Development Review Board (DRB)
Review Comments
Utility Development Section
Reviewer: Blaine Carter, P.E.
Phone: 505.415.9188

DRB Project No: PR-2021-005195	Date: 12/01/21	Item No: #7
Zone Atlas Page: D-17	Legal Description: Tract 6A-1, Unit 1, Journal Center Phase 2 Location: STREETS 7501 JEFFERSON ST NE between JEFFERSON ST and MASTHEAD ST NE	
Request For: SI-2021-01747 – SITE PLAN

DEKKER/PERICH/SABATINI – WILL GLEASON agent for **JC SIX LLC** requests the aforementioned action(s) for all or a portion of: **TRACT 6A-1, UNIT 1, JOURNAL CENTER PHASE 2** zoned MX-H, located on **7501 JEFFERSON ST NE** between **JEFFERSON ST** and **MASTHEAD ST NE** containing approximately **5.1536** acre(s). (**D-17**)

1. SITE PLAN APPROVAL REQUEST FOR MULTI-FAMILY APARTMENT HOME COMMUNITY

A1 SITE PLAN
 1" = 40'-0"
 0 20' 40' 80'

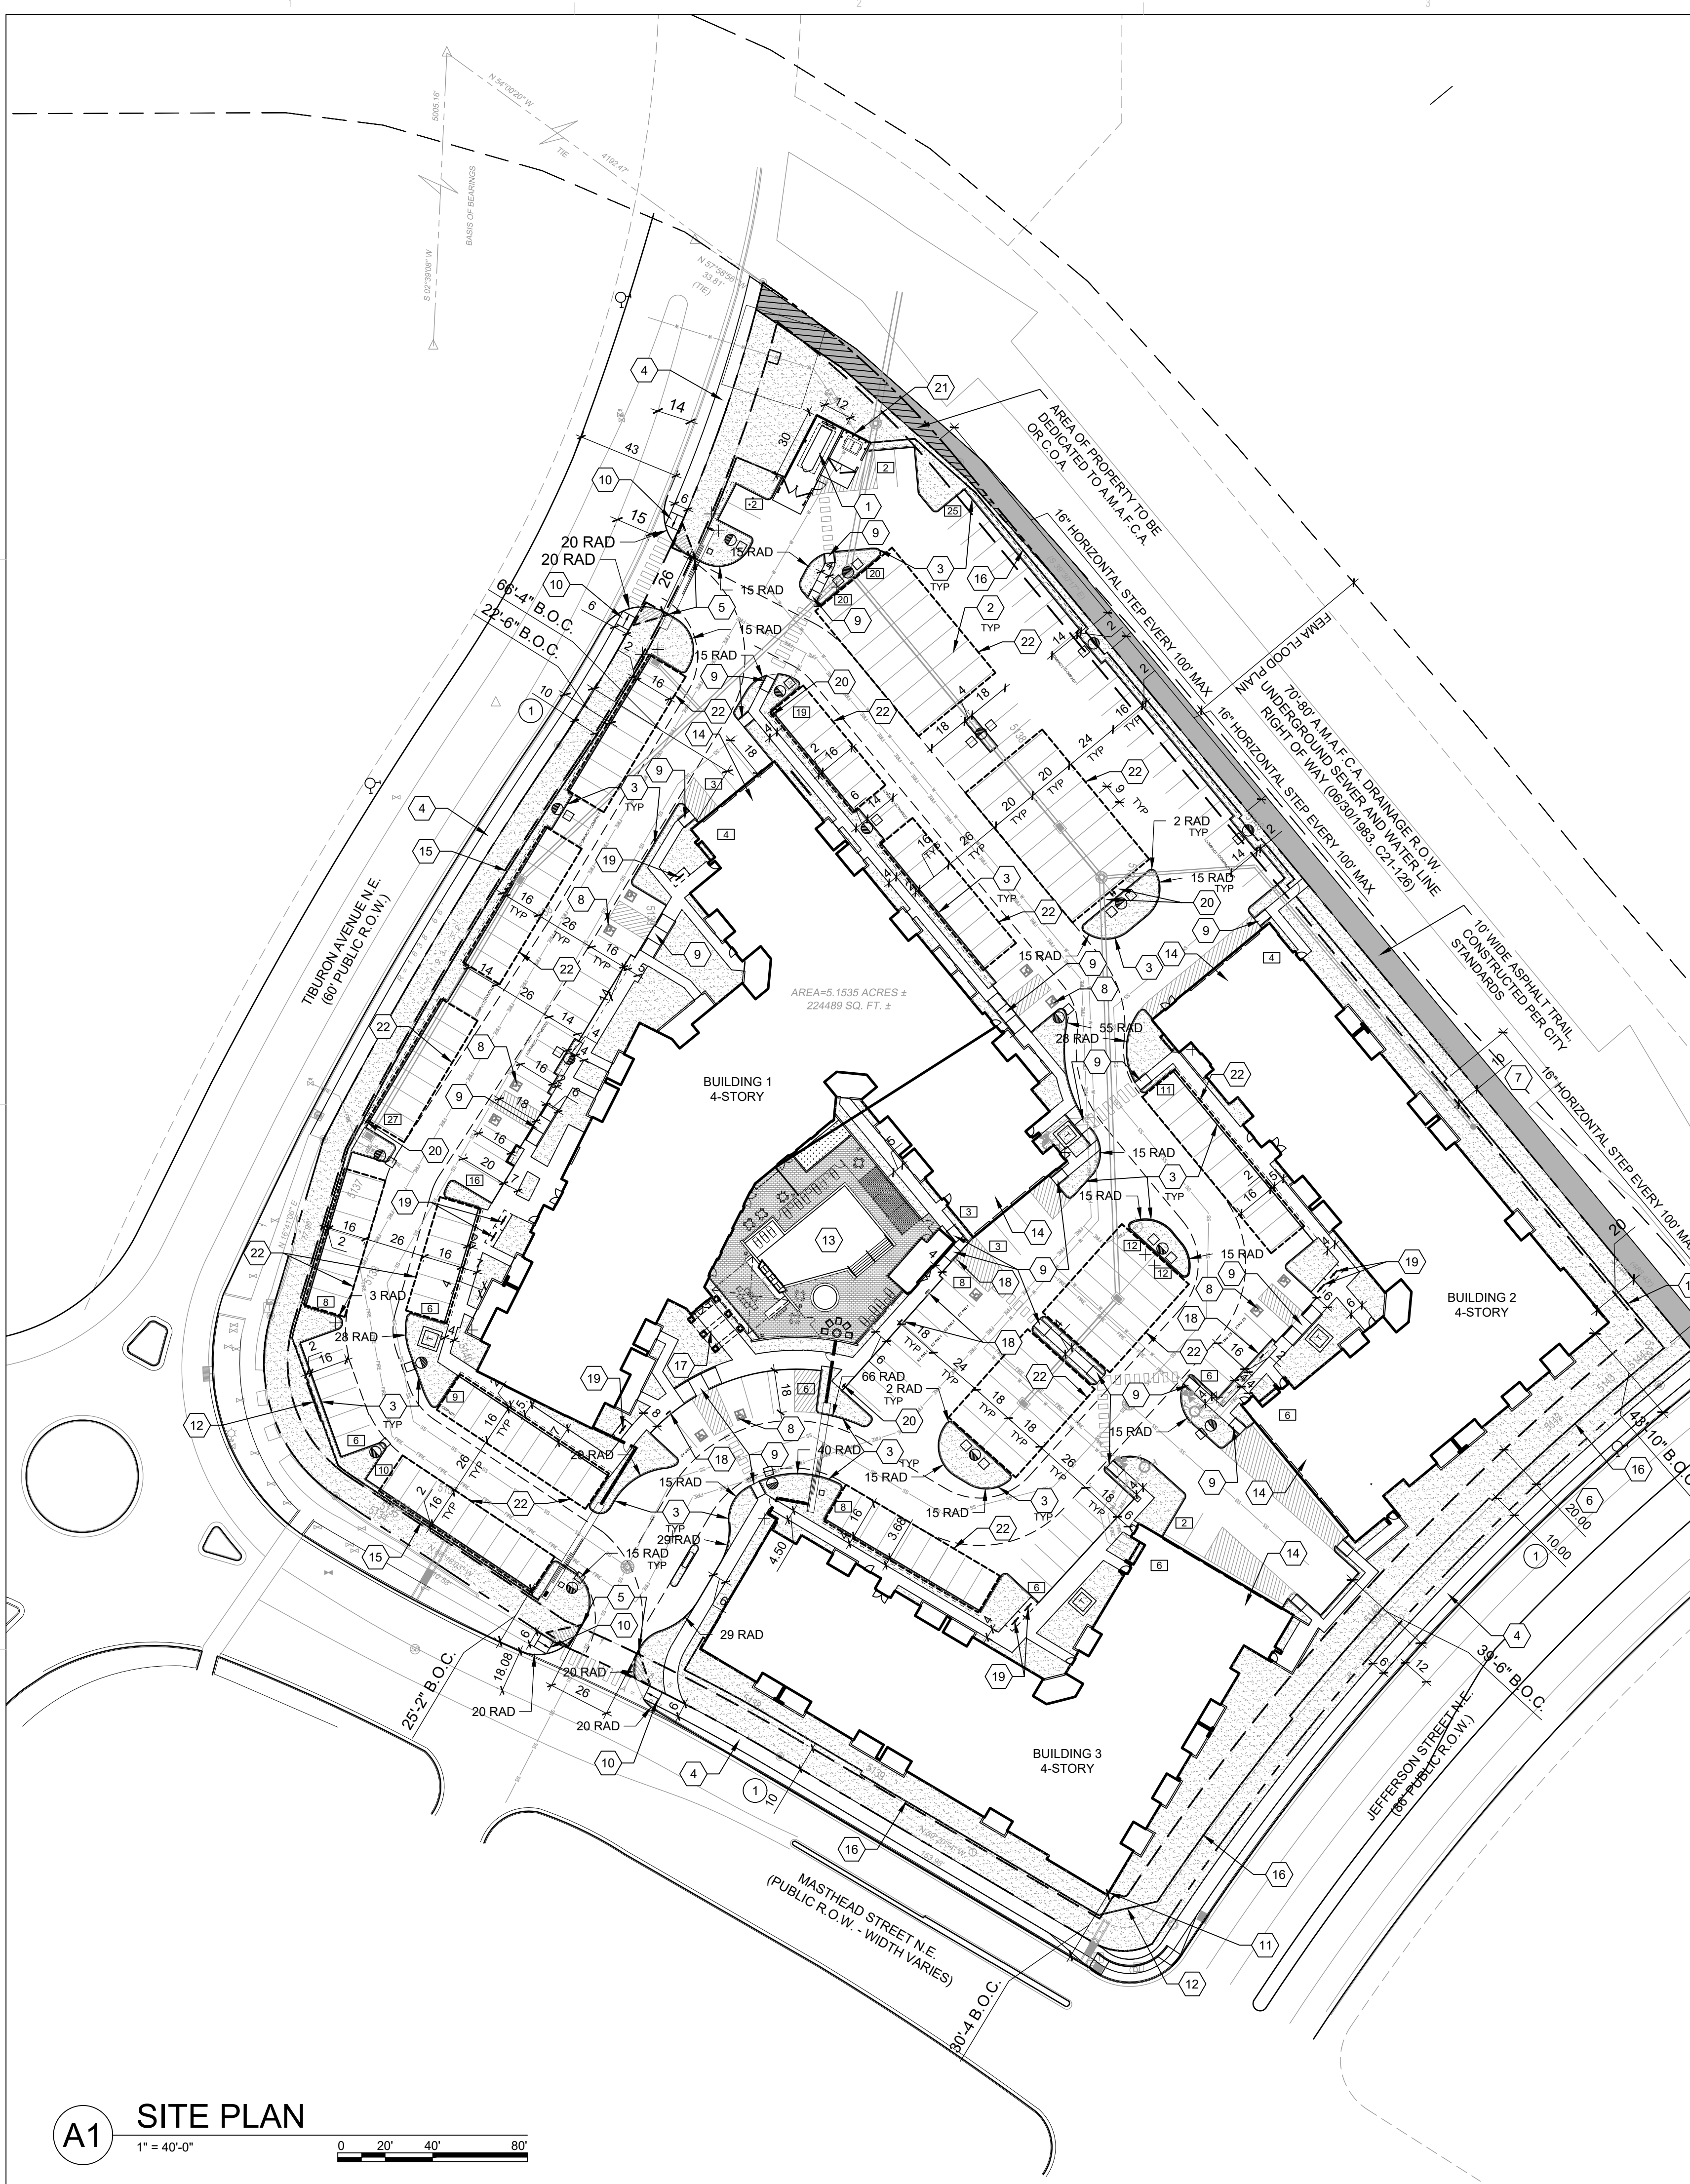
1. For Building “B”, a 6-foot sidewalk shall be provided from the handicapped spaces to the building.

2. If the standard 18-foot parking spaces are achieved with overlap onto curb, call out the overlap to show that it meets the minimum standard. When unable to meet the minimum parking space dimension requirement, designate spaces as “Compact” at the back of the parking space while meeting maximum requirements on the number of compact spaces.

4. Indicate all electrical charge stations that are called out under the parking calculations.

5. Show adjacent roadway width and lanes on all roadway frontages. Indicate accessways on opposite side of roadway where medians are not shown to indicate lack of turning movement conflict.

10. Due to speeds on surrounding streets, call out clear sight triangles on both the site plan and on the landscaping plan due to intersection sight distance. Show note on standard height restrictions for each plan.

11. Show all curb radii that will match DPM standards. Curb radii need to be called out at the entrances, around the 90-degree bend at the south end and just south of Building “B”.

Response – Building “B” is now labeled Building 2 in the revised site plan. The 6’ wide sidewalk is shown and dimensioned.

Response – 2’ overhang has been dimensioned at all spaces where the minimum length is achieved by using the overhang. Compact car spaces have been labeled and shall comply with DPM section 7-4(K)(4).

Response – The EV stations are labeled on the site plan and called out by keyed note #18.

Response – Adjacent roadway widths and lanes are indicated on the site plan, see also sections C1, D2, and D4 on SDP1.3

Response – Clear sight triangles are called out on both plans. See keyed note #5 on the site plan and general note ‘F’ on the landscape plan for standard height restrictions.

Response – Curb radii has been called out throughout the development including at the locations noted above. Building ‘B’ is now labeled Building 2.

B5 BLADE SIGN

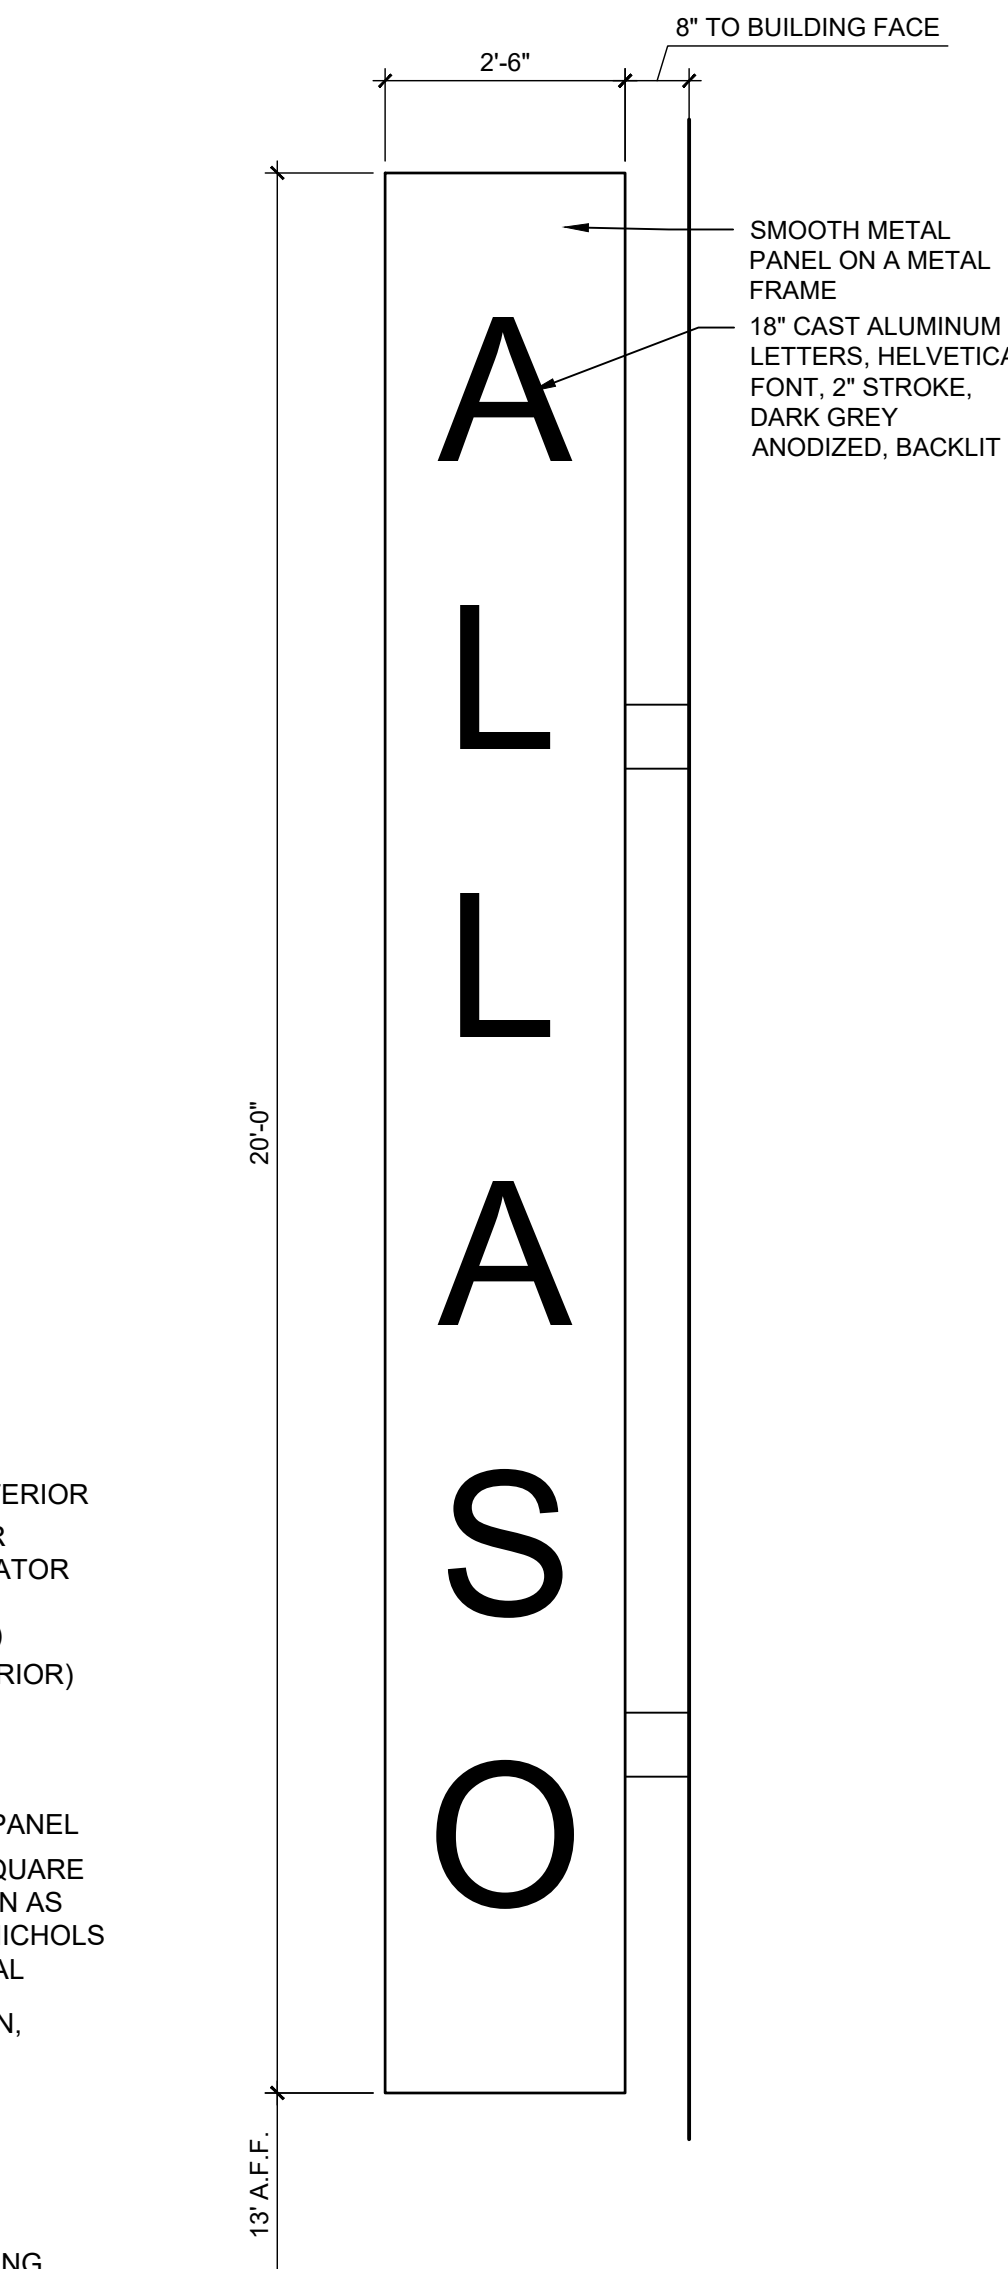
3. The number of bike racks shown on the site plan do not seem to match the number required. Provide a detail showing spacing requirements for the bike racks.

Response – The required number of spaces is 25. There are 16 spaces outside throughout the site and indicated by keyed note #19 on the site plan. There are an additional 10 spaces in an indoor bike storage room. See detail B5/SDP1.2 for spacing requirements.

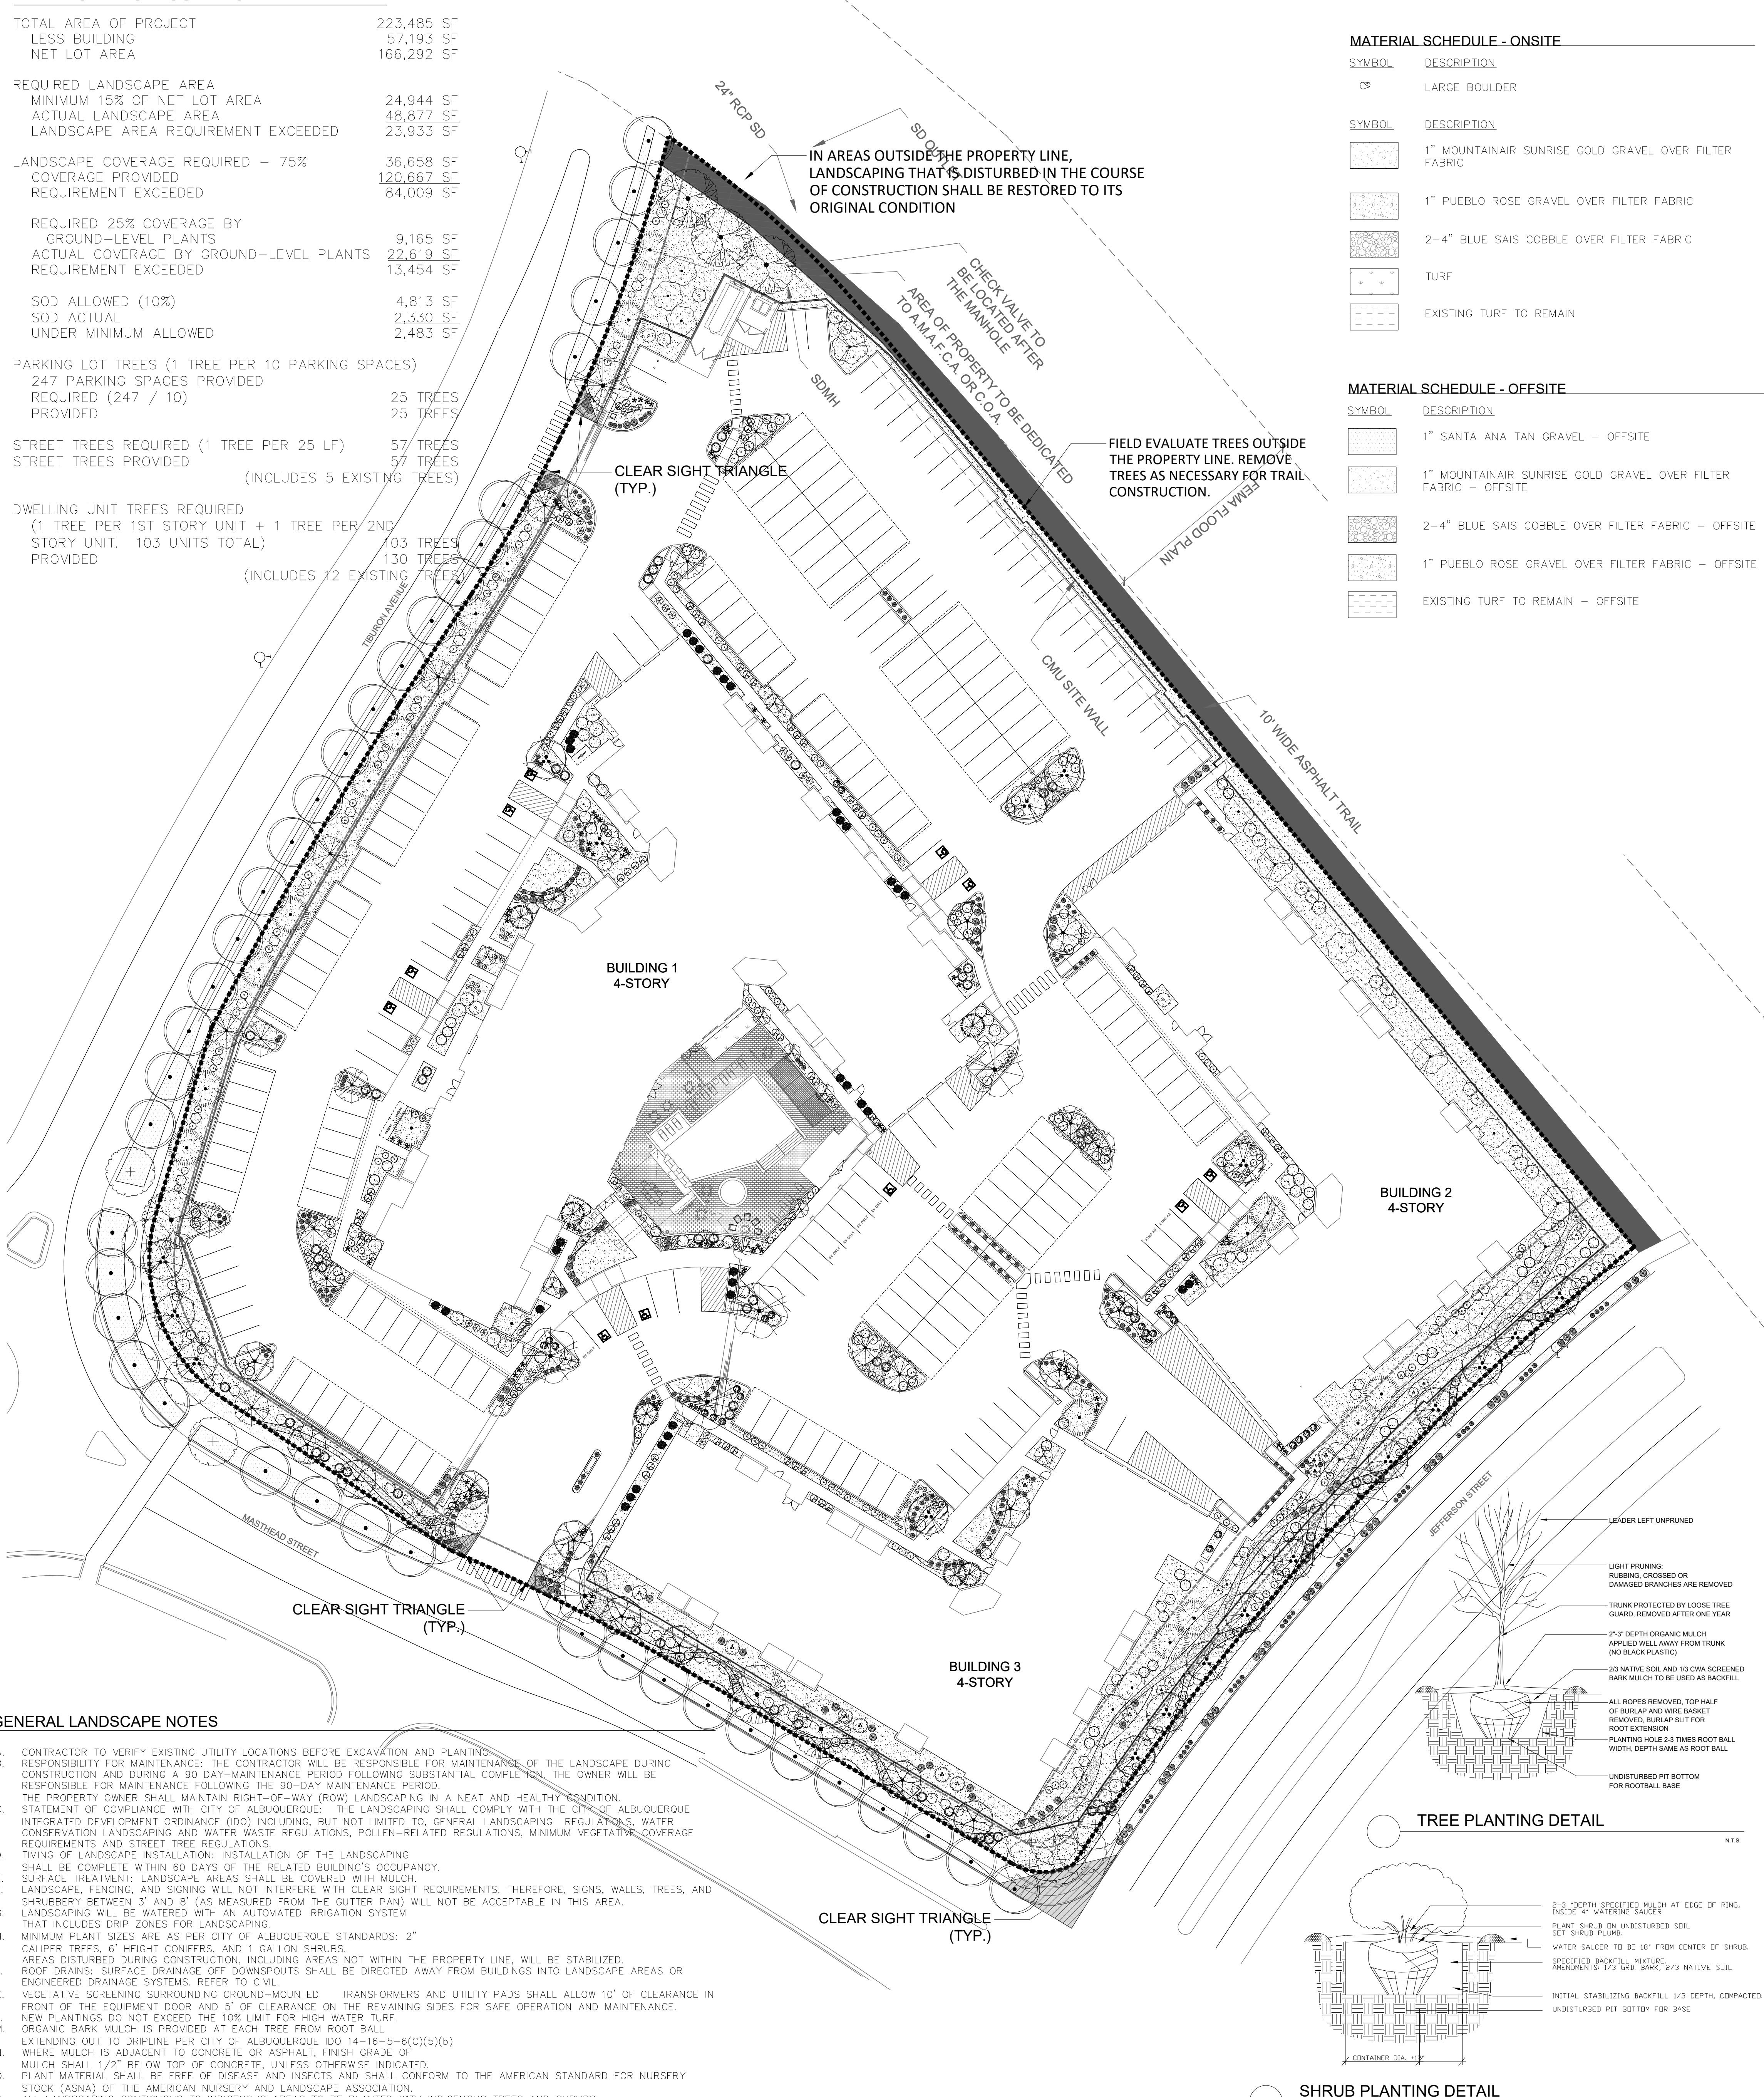
Jefferson St NE is a Community Principal Arterial, and Masthead St NE and Tiburon St NE are Major Collectors, requiring street trees. The legend shows Berinda Ash for Tiburon St and Masthead St. Pursuant to 5-6(C)(4)(b), trees should be selected from the Official Albuquerque Plant Palette. Ash is only Conditionally Recommended due to high water use. The Parks and Recreation Department (PRD) is a partner with the Nature Conservancy who developed a Climate Ready Tree List for Albuquerque. PRD encourages developers to use this list for street trees (see insert below).
